LISTED BUILDING CONSENT

Reference: H11-0938-15 **Date of Decision:** 3rd December 2015

Location: Holmhurst 24 Wisbech Road Long Sutton Spalding

Description: Repair/replacement of existing sliding sash windows, front door and amendment of side window to kitchen from fanlight to casement window

Existing & Propsoed Side Elevation

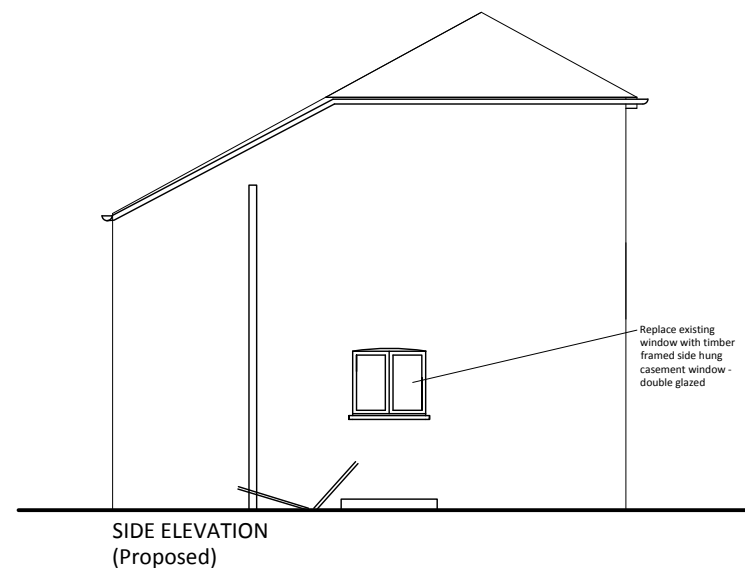
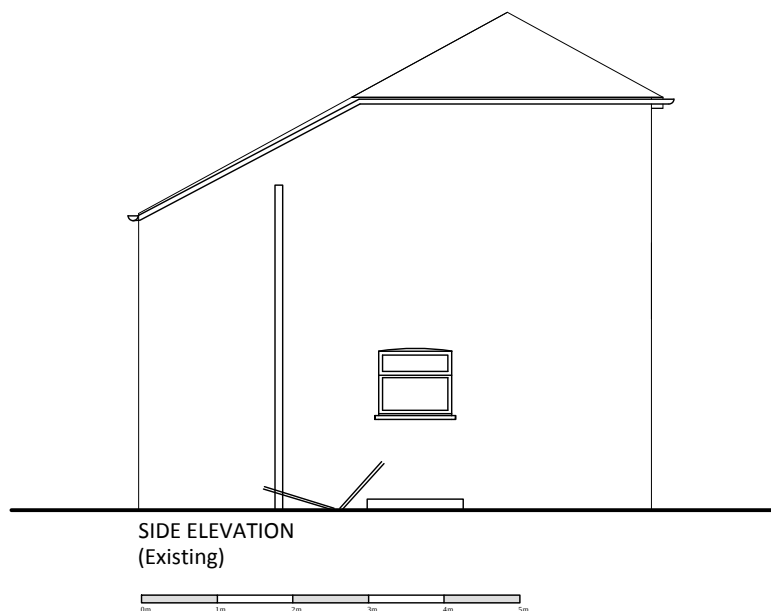
- 4 Details of the window and frame of the replaced side elevation window hereby permitted shall be submitted to and approved in writing by the Local Planning Authority prior to its installation. Such details shall indicate, at a scale of not less than 1:10, the longitudinal and cross-sectional detailing (including reveals), cill and lintol detailing, and means of opening. The window frames shall be installed in accordance with the approved details and thereafter so maintained.
